**City of Albuquerque**

RE: PROJECT NO. 4369.90, DIAMOND SHAMROCK DECELERATION LANE, (MAP NO. K-10)

RE: ENGINEER'S CERTIFICATION FOR DIAMOND SHAMROCK @ BLUEWATER  
& COORS, NW (K-10/D20B) CERTIFICATION STATEMENT DATED  
DECEMBER 16, 1991

RE: DRAINAGE PLAN FOR DIAMOND SHAMROCK  
(K-10/D20B) ENGINEER'S STAMP DATED MAY 31, 1991

GRADING AND DRAINAGE PLAN

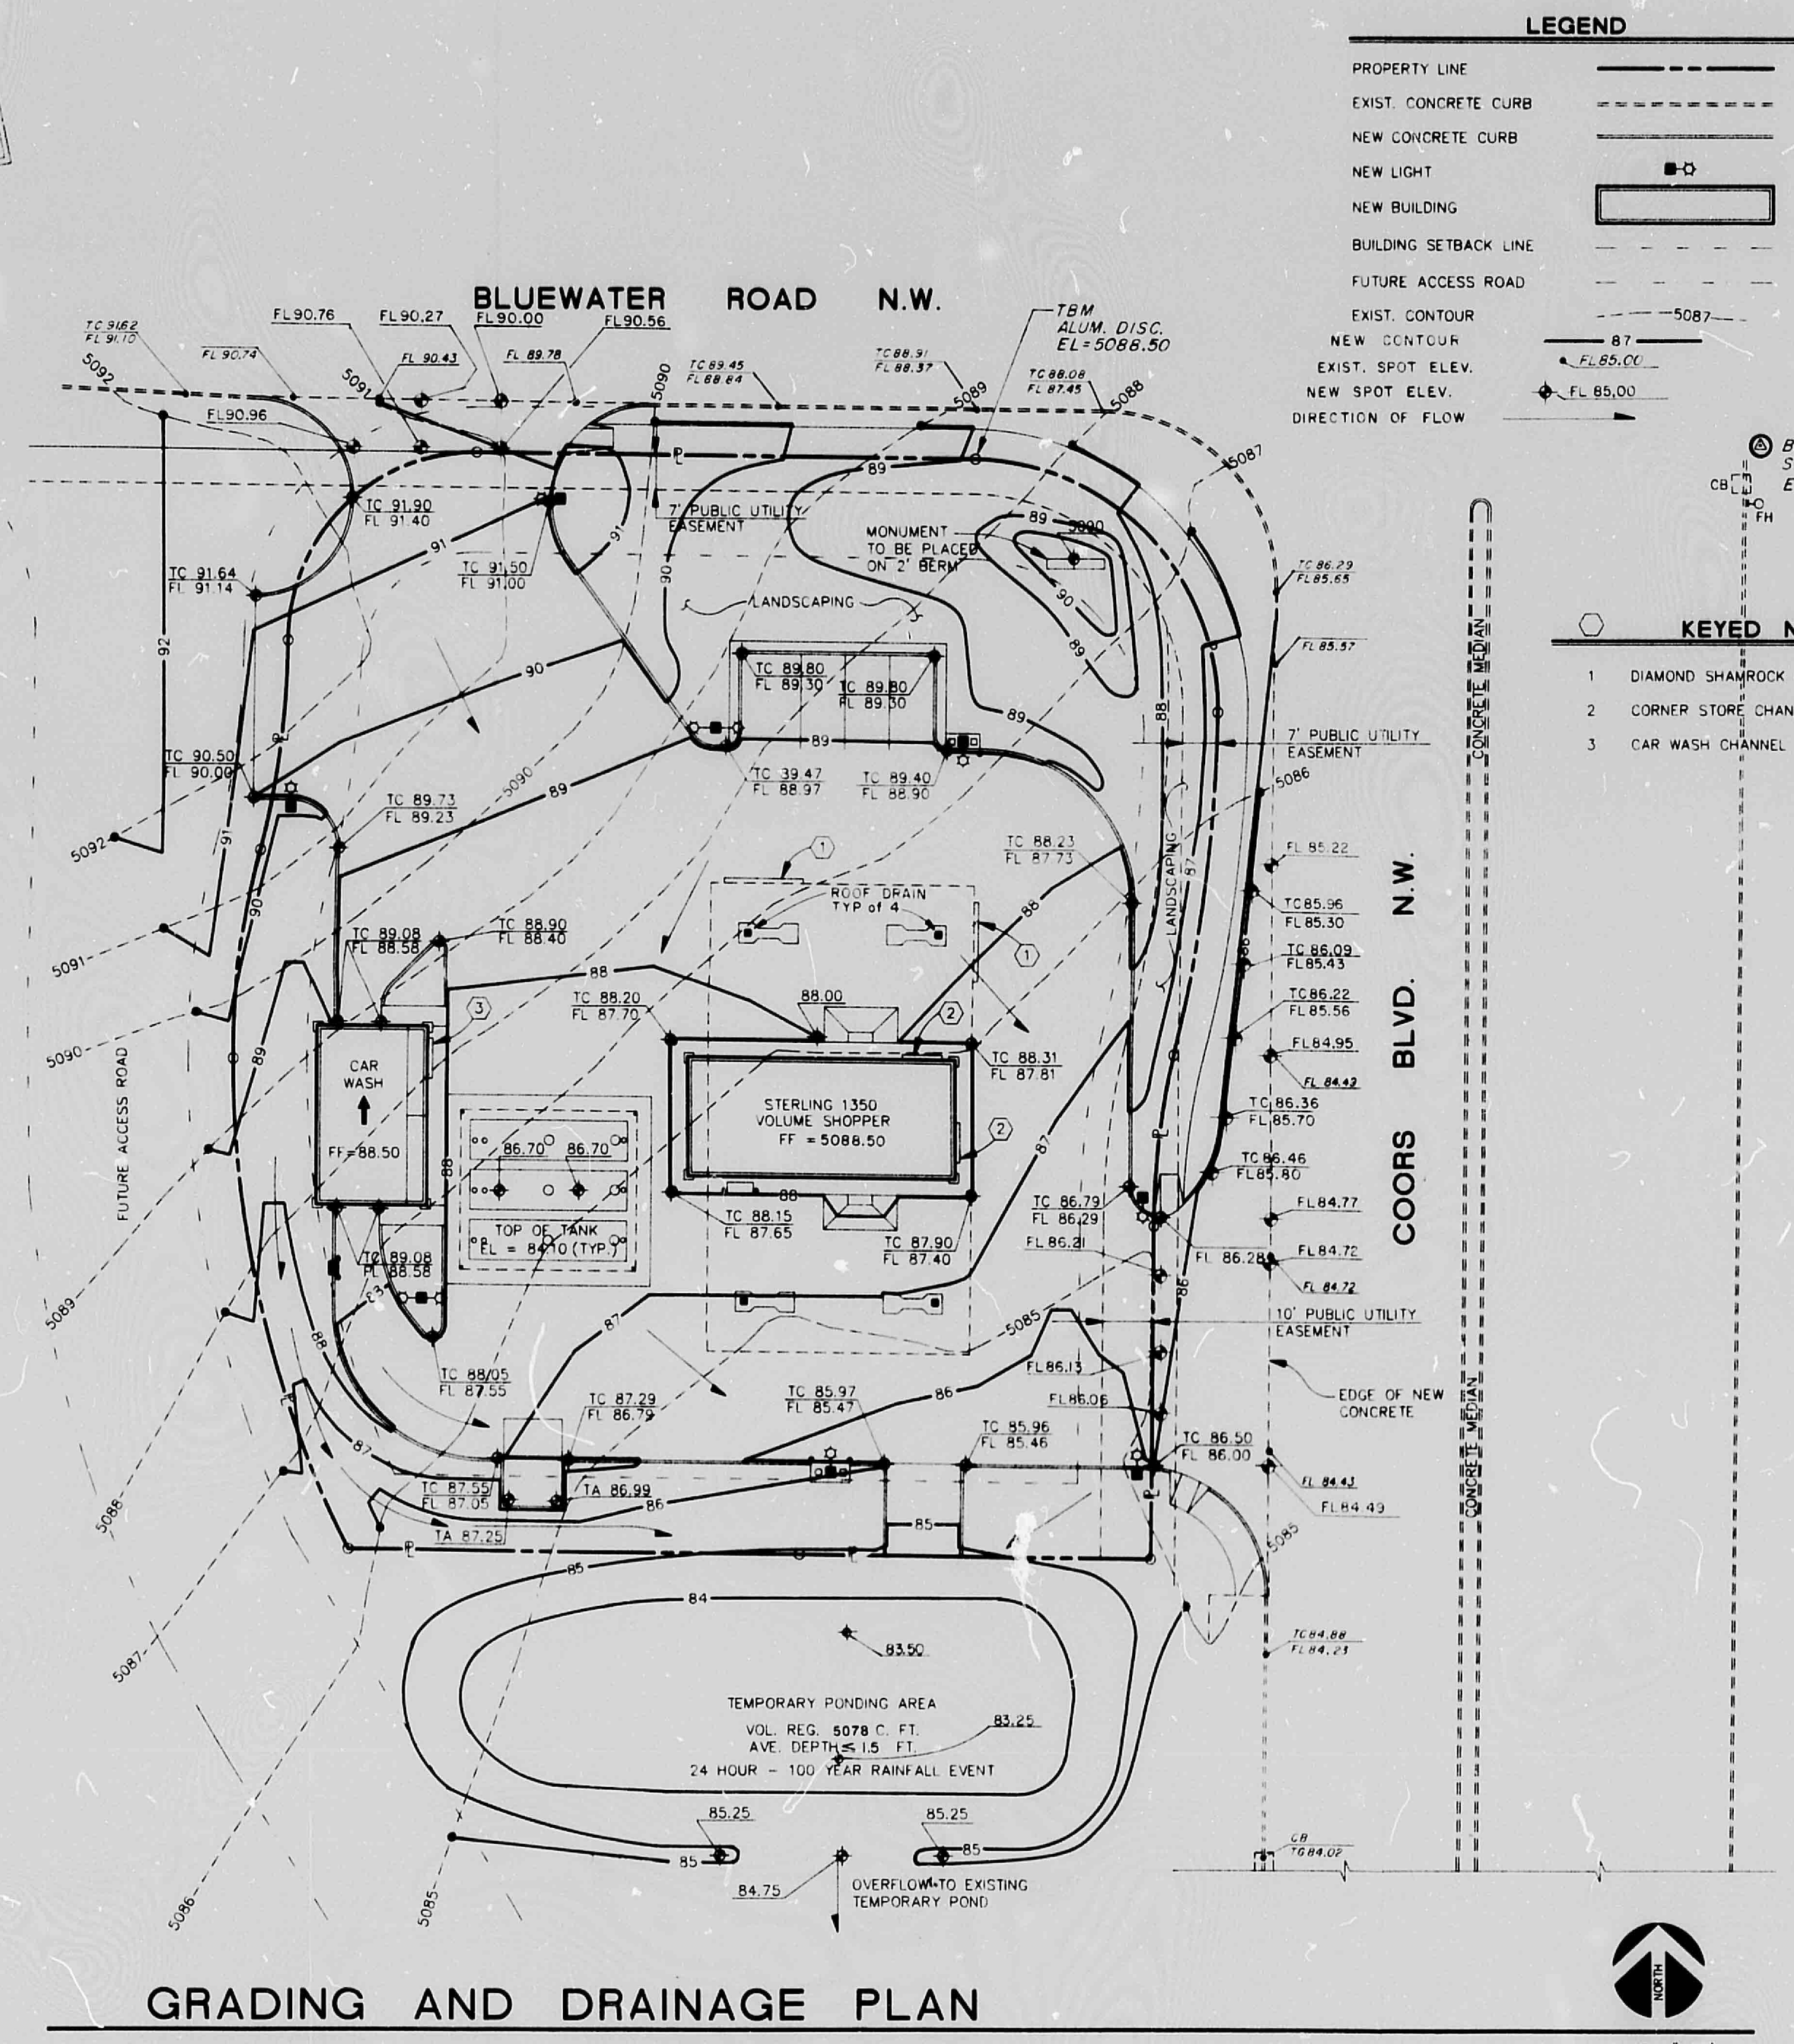
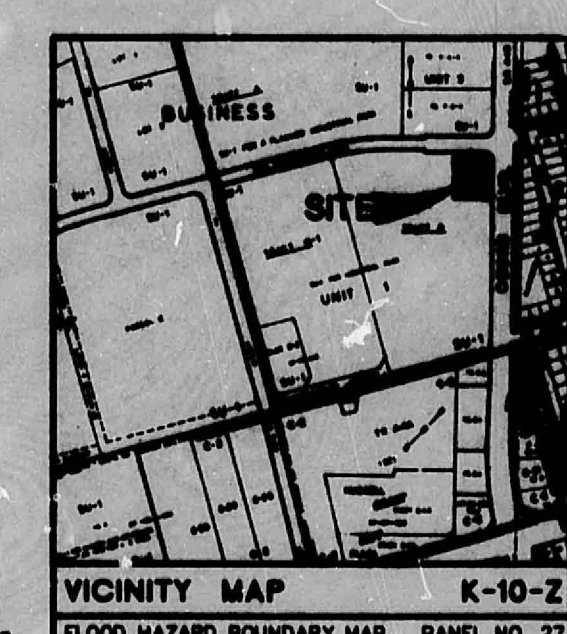
1. You must use the correct values from NOAA Atlas for both the 10 year 24 hour and 100 year 24 hour storms to calculate your flow rates and volumes.
2. The pre-design recap indicates that you must pond the 10 year 24 hour storm, and that the difference between the 10 year 24 hour and the 100 year 24 hour storms will be allowed to spill over onto the adjacent ponds.
3. Show top of curb and flow line elevations all along Bluewater and Coors.
4. Bench mark and TBM must be shown and described.
5. Finish floor elevations to full mean sea level.
6. Location and direction of the roof drains.

7. Your plan drawing indicates that you are proposing to do some grading outside the property line. We will need concurrence from the adjacent property owners.
